Rezoning Transportation Analysis
Petition Number: Insert Zoning Petition #2020-195
General Location Identifier: Tax ID 21159315

Revision Log:

Date	Description
01-21-21	First Review (LJ)
02-15-21	Second Review (LJ)
03-24-21	Third Review (WB)

REZONING PETITION #2020-195  
 FOR  
 REA ROAD TOWNHOMES  
 4245 REA ROAD  
 CHARLOTTE, NORTH CAROLINA

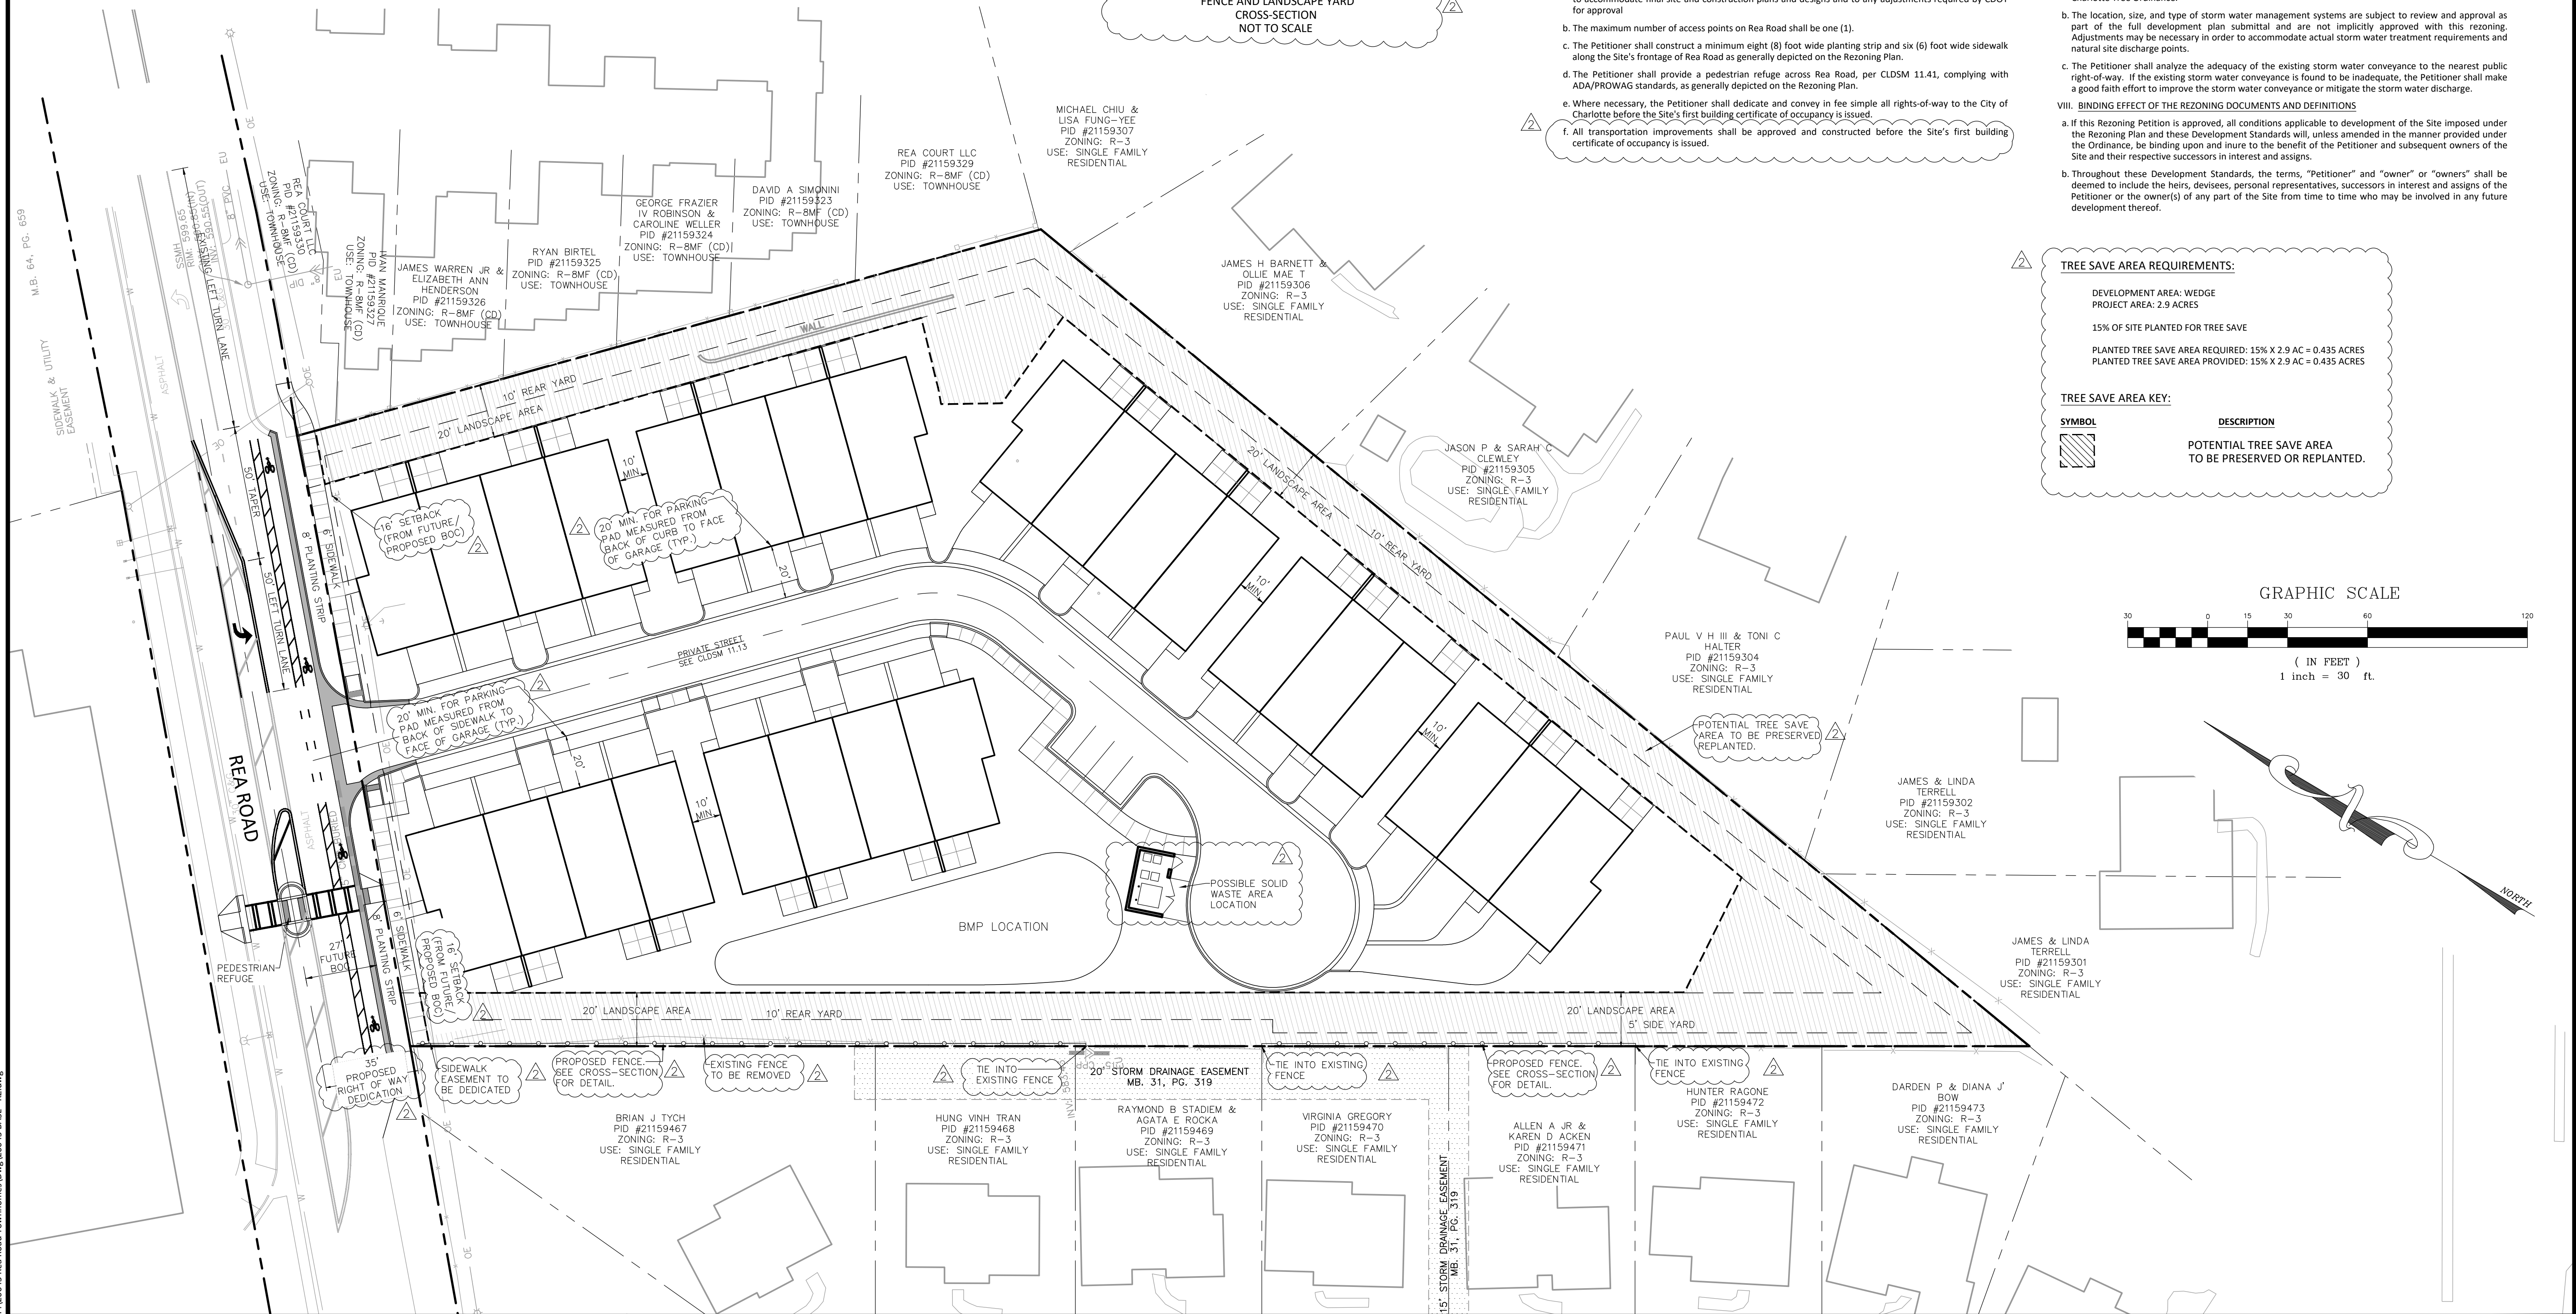
1. **Curblin**e: The proposed zoning district has a setback measured from back of the existing curblin
e.
Rea Road (NCDOT): ~~The future location of back of curb and gutter is 27' from the Rea Road centerline. Label and dimension the curb and gutter from the centerline for each road on the site plan.~~

3. ~~**OUTSTANDING (02/15/21):** Revise site plan and conditional note(s) to commit to dedicate 35' right-of-way from the road centerline. The site plan shall label and dimension the right-of-way from the road centerline per Chapter 20 of the City Code. **Resolved (3/24/21)**~~

4. ~~Revise site plan and conditional note(s) to commit to construct an 8-foot planting strip, and 6-foot sidewalk on Rea Road per Chapter 19 / Chapter 20. The site plan shall label and dimension both items from the back of curb and gutter and road centerline.~~

5. ~~Provide a left turn lane on Rea Road as required by NCDOT. Restripe Rea Road, per NCDOT Roadway Standard Drawing for PAVEMENT MARKINGS Turn Lanes, 1205.05, to accommodate the left turning lane to include storage.~~

6. ~~Site plan and conditional note(s) revisions are needed to meet CLDSM standards. Provide a pedestrian refuge across Rea Road, per CLDSM, 11.41, complying with ADA/PROWAG standards. The pedestrian refuge also meets the Charlotte WALKS Policy.~~

7. ~~Site plan and conditional note(s) revisions to label the private street as a CLDSM, 11.13 Private Street.~~

8. ~~**OUTSTANDING (02/15/21):** A site plan note(s) specifying dedication and fee simple conveyance of all rights-of-way to the City before the site's first building certificate of occupancy is issued is needed. CDOT requests rights-of-way set at 2' behind back of sidewalk where feasible.~~

9. ~~**OUTSTANDING:** Adjust note III.f. to read that all transportation improvements will be approved and constructed before the site's first building certificate of occupancy is issued. The petitioner may phase transportation improvements if said improvements and phasing are explicitly described in site plan notes.~~
